Our Ref: M/53/19/PL

**Town & Country Planning Act 1990 (as amended)
Town and Country Planning (Development Management Procedure) (England) Order 2015
Application for Planning Permission**

Development Demolition & erection of 1 No. dwelling.
Location 7 Alleyne Way Elmer Middleton-On-Sea

7 Alleyne Way, Bognor Regis, PO22 6JZ

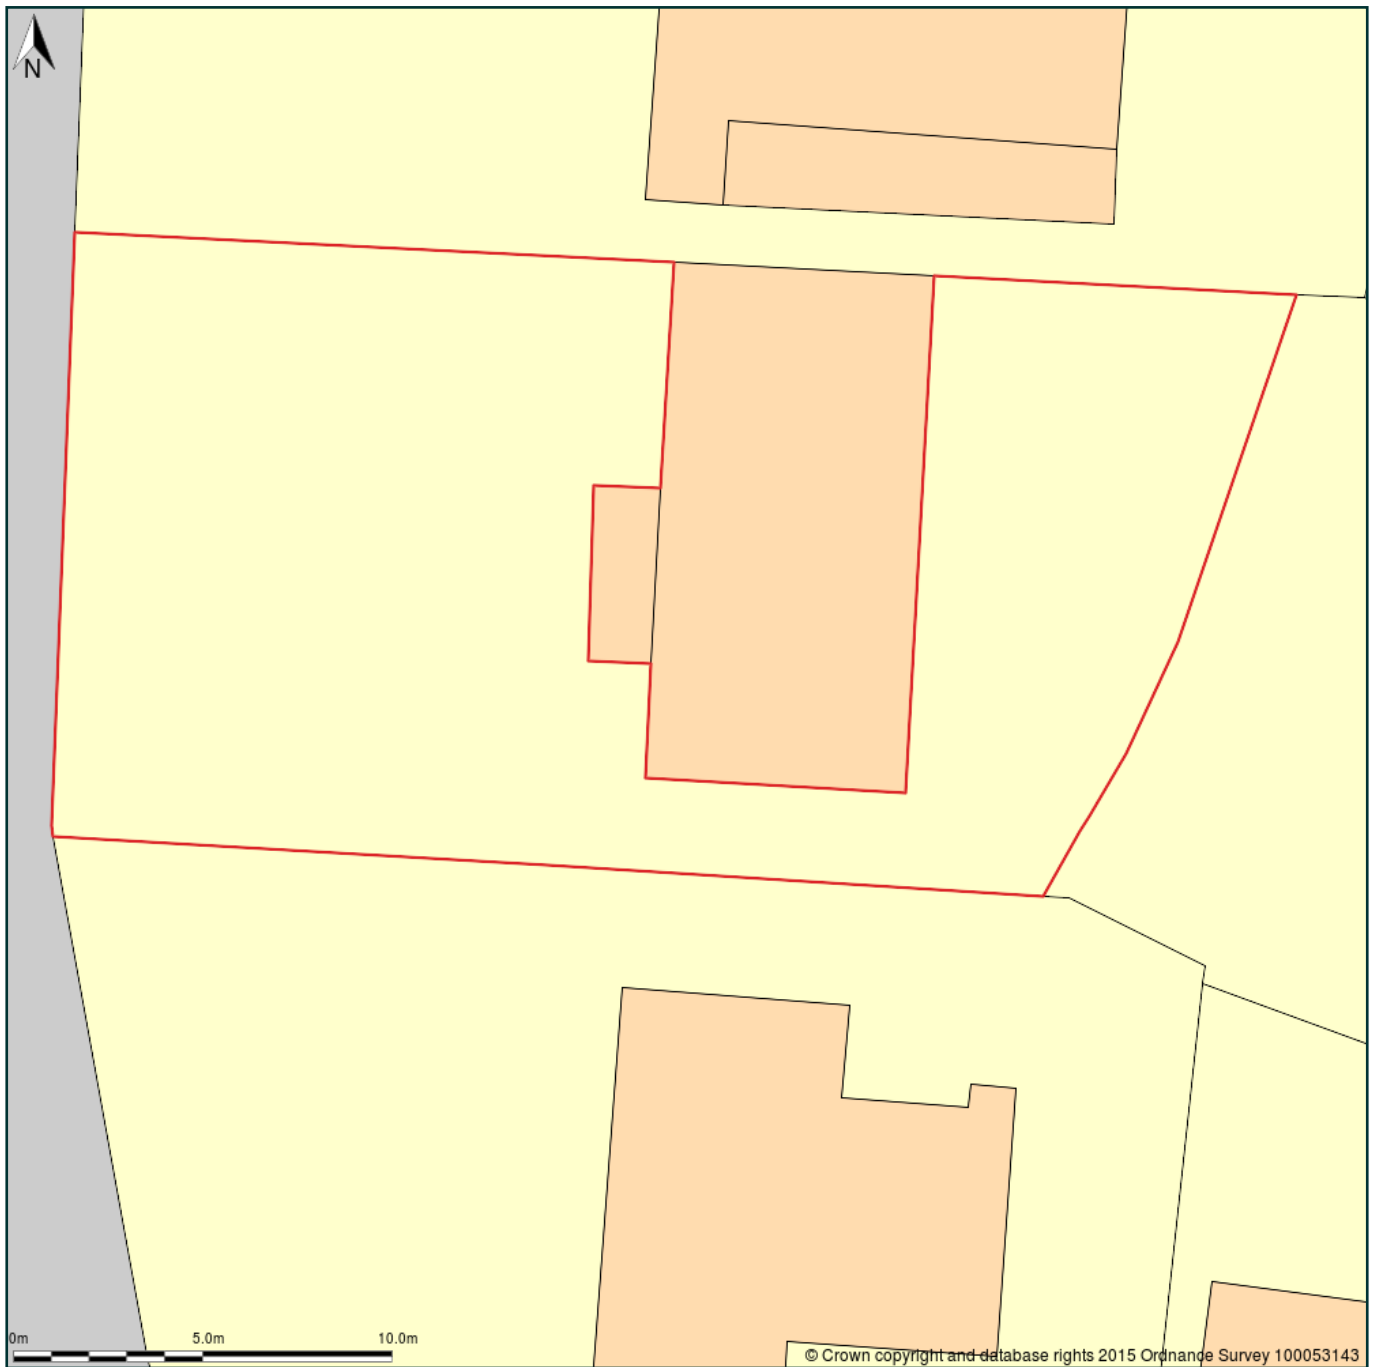
Block Plan Amend

Please clearly show the outline of the existing house.

Please confirm the number of parking spaces that are proposed.

Drawing Title:
EXISTING FLOOR PLANS AND ELEVATIONS

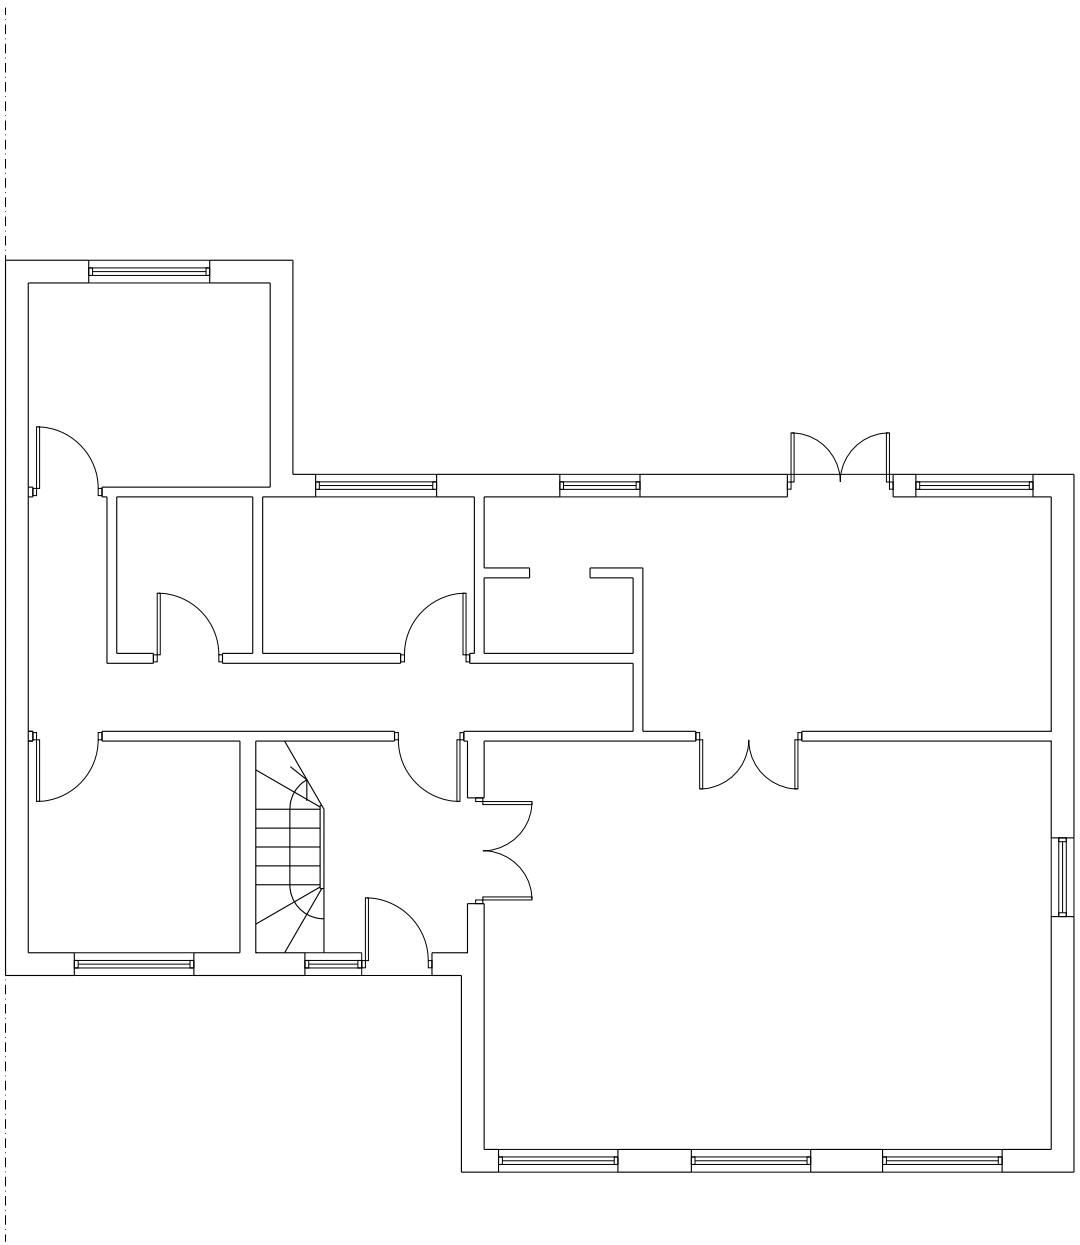
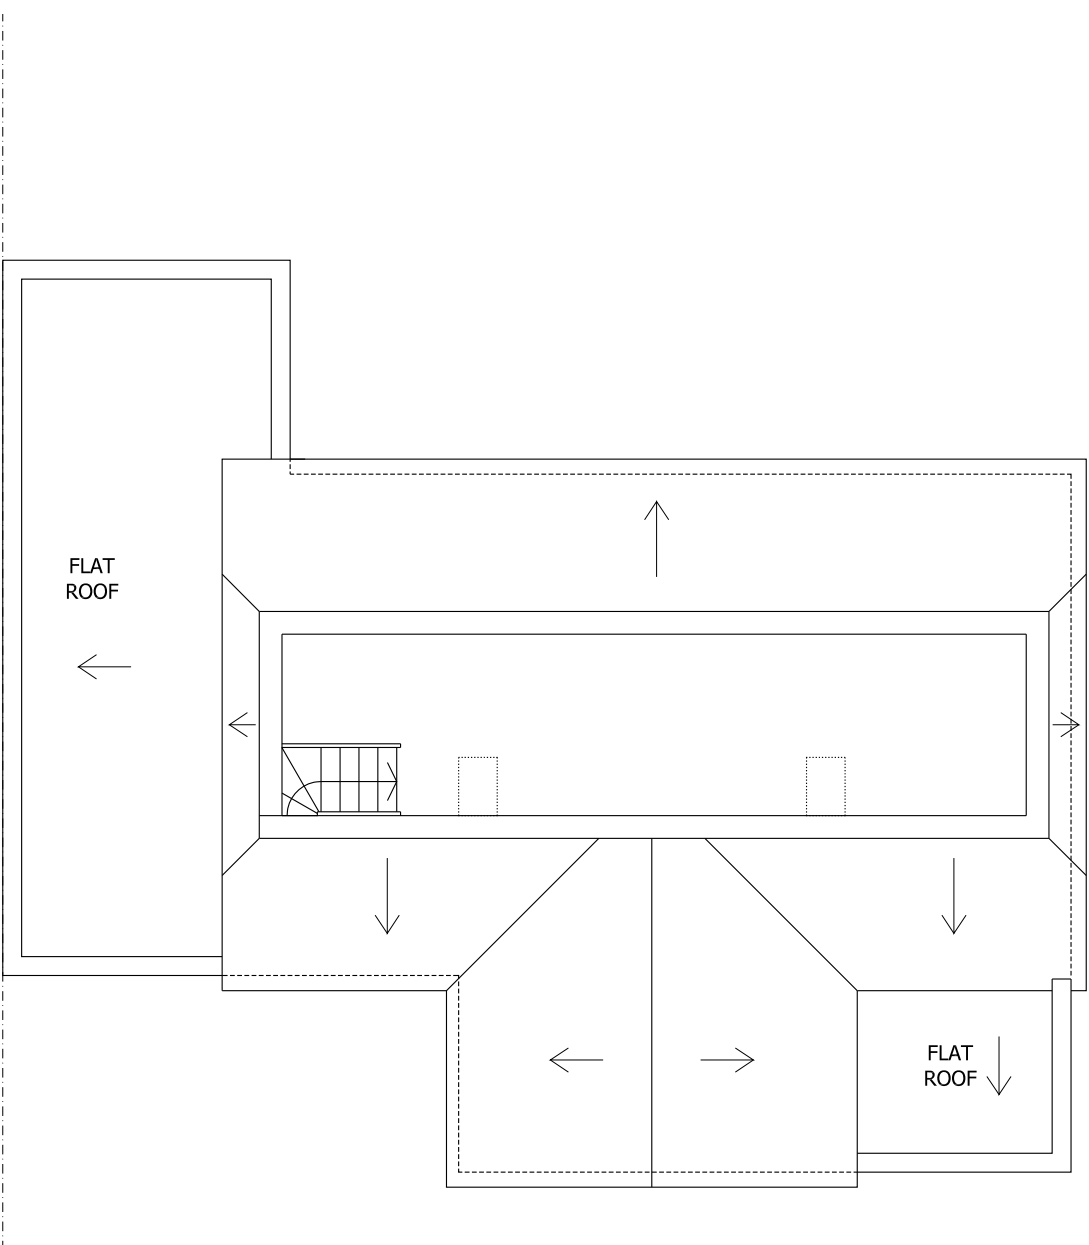
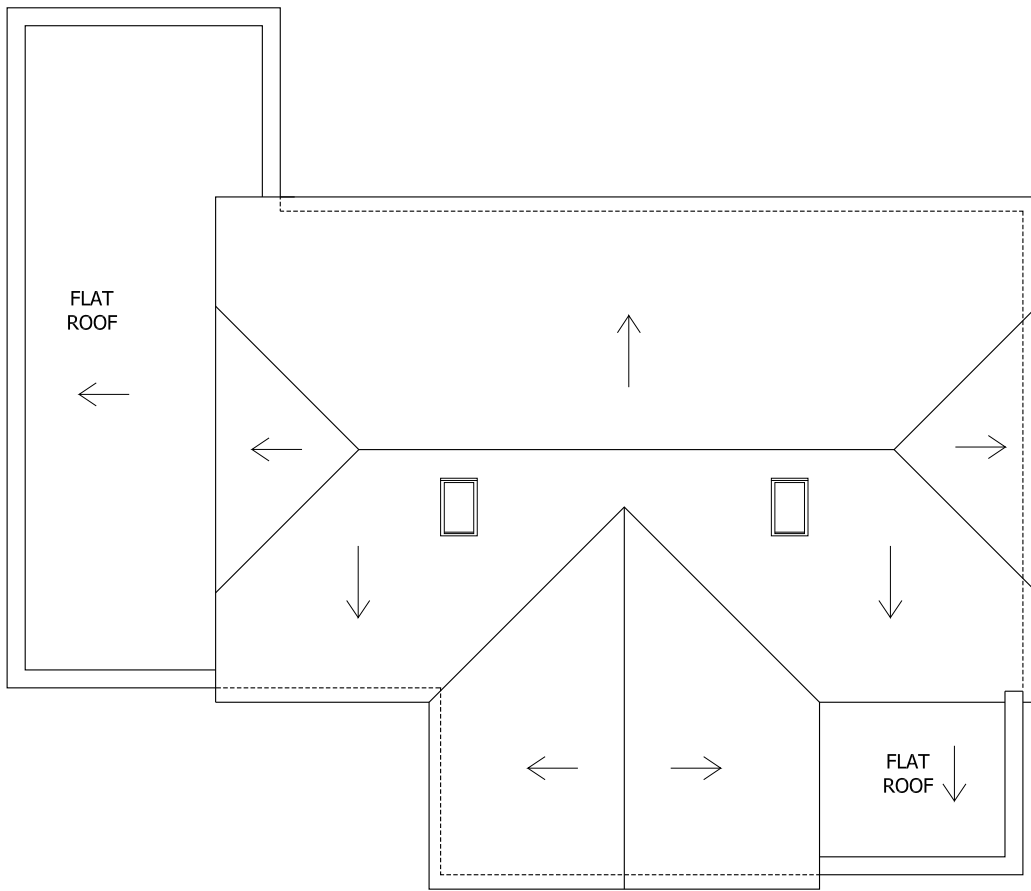
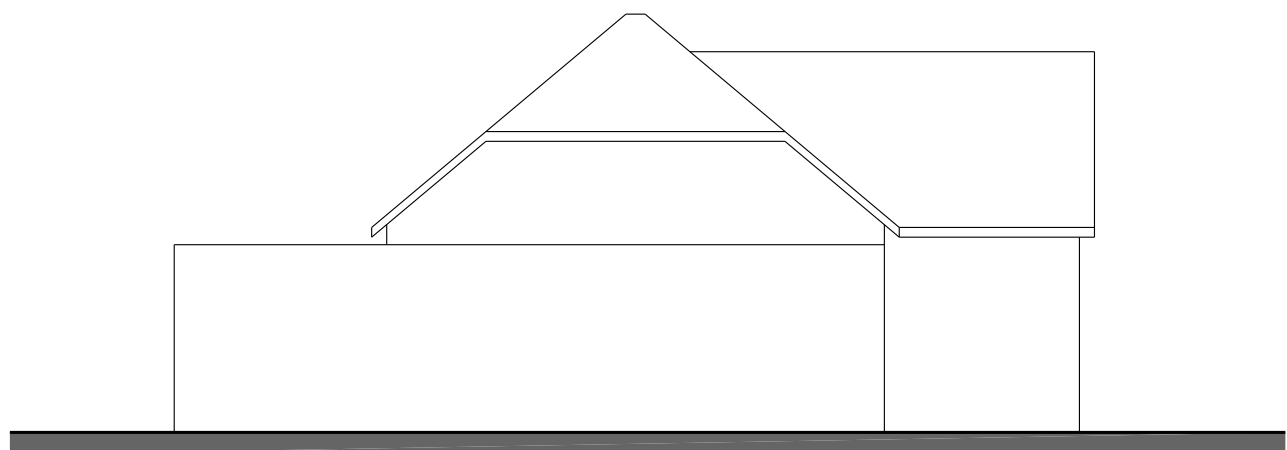
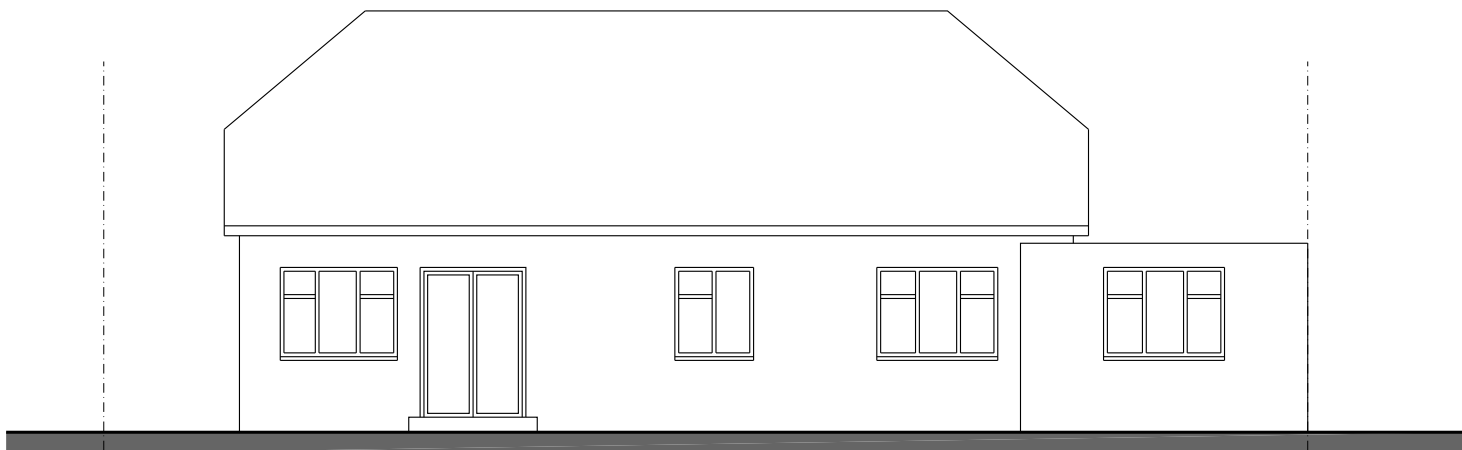
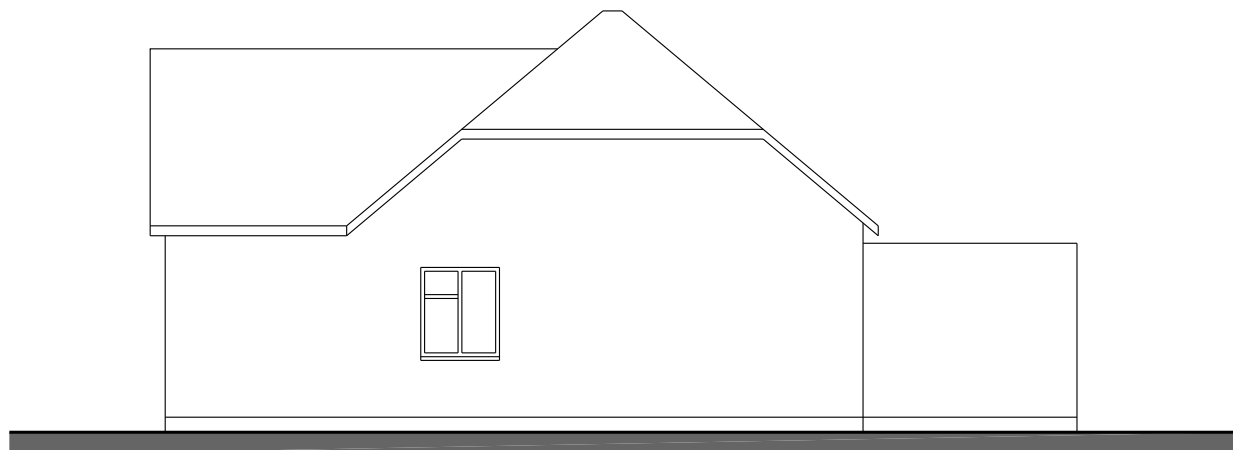
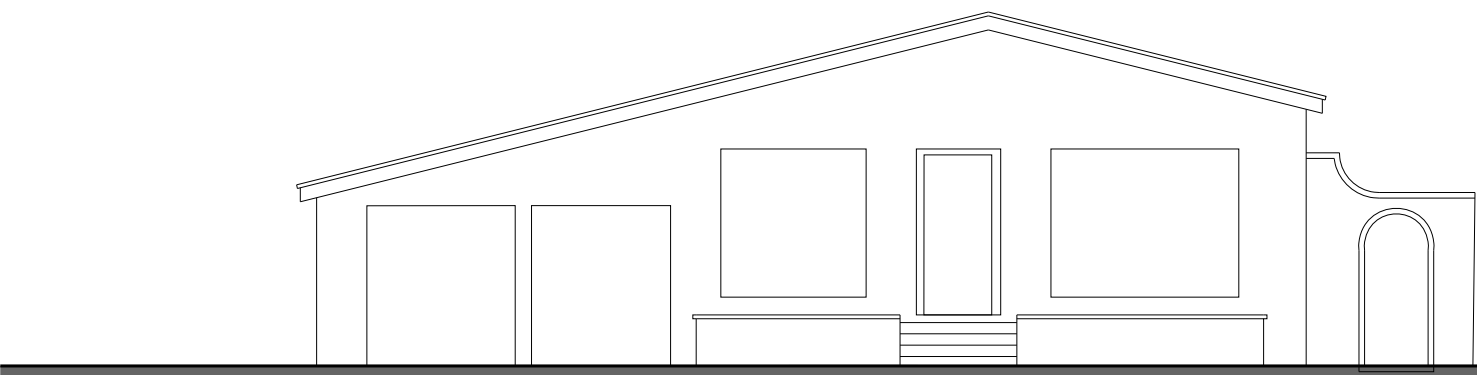
Please provide existing floor plans and elevations.

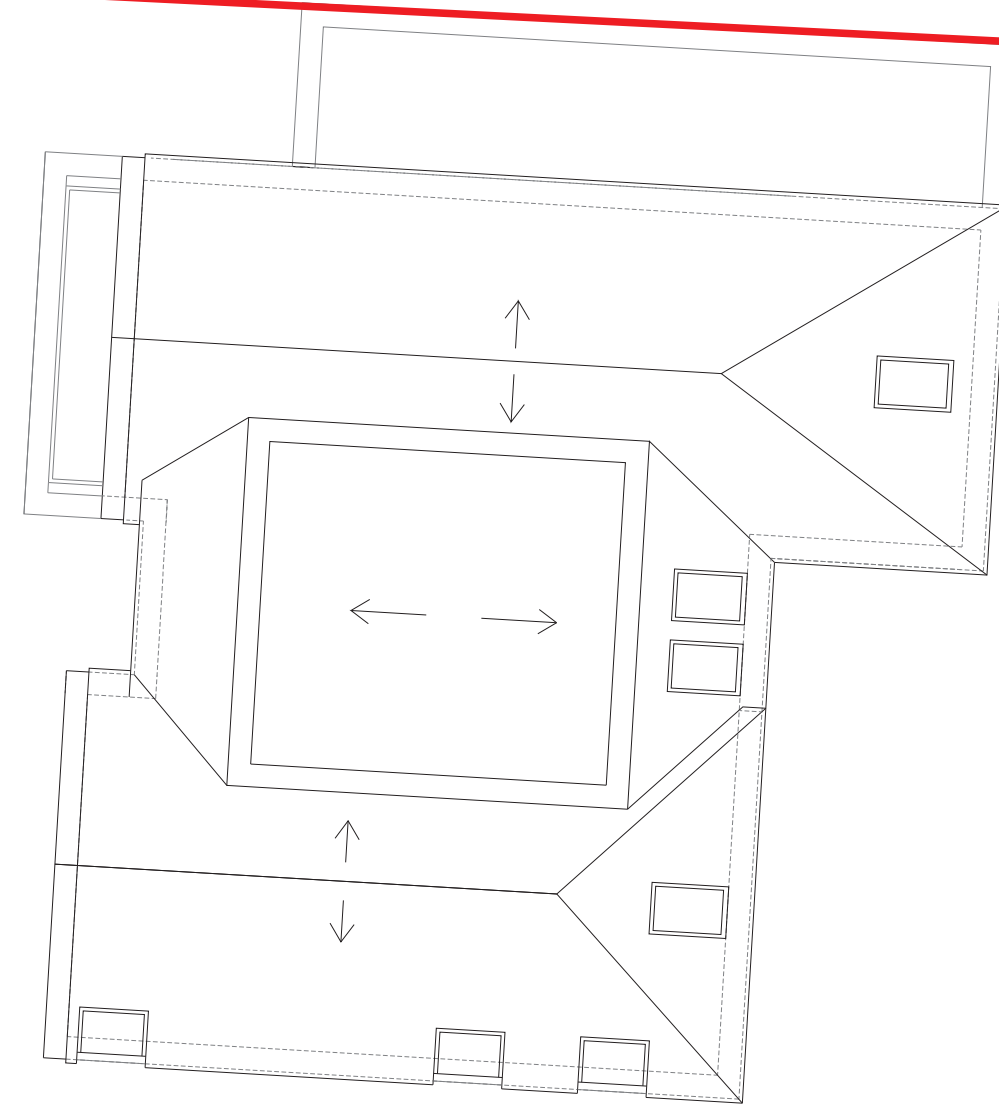
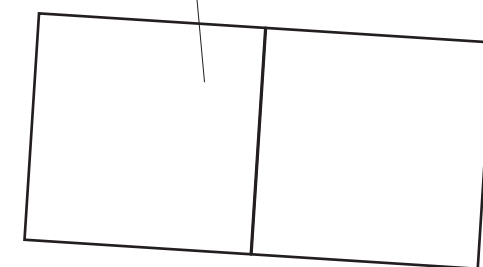
Bin Storage and Collection Provision

This application requires the provision of bin storage/collection facilities. Please provide details in the format as set out in the Local Validation Requirements so that Environmental Services are able to assess whether the proposal is acceptable.
